Consultee Comments for Planning Application

SDNP/24/00421/TCA

Address: 1 Albion Villas Hill Brow Road Liss Hampshire GU33 7LA

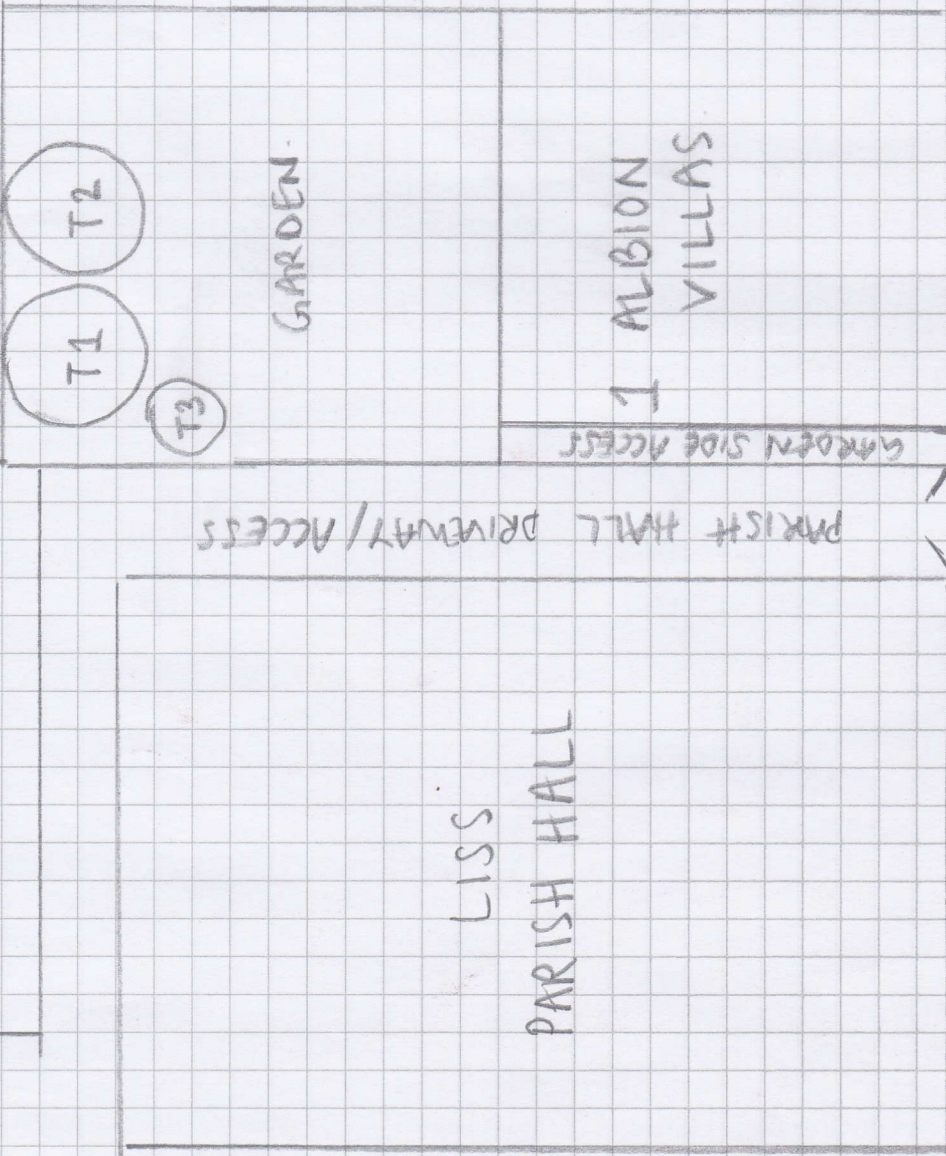
The trees are on the east and north sides of the garden so shading of sunlight will be limited.

Multi-stemmed Cypresses:

I am not sure that reducing shading of a garden and dropping of foliage is a justification for complete removal. One stem is partly overhanging the council office.

Viburnum?

This has a good shape, and I assume that judicious pruning could maintain it as a good specimen.
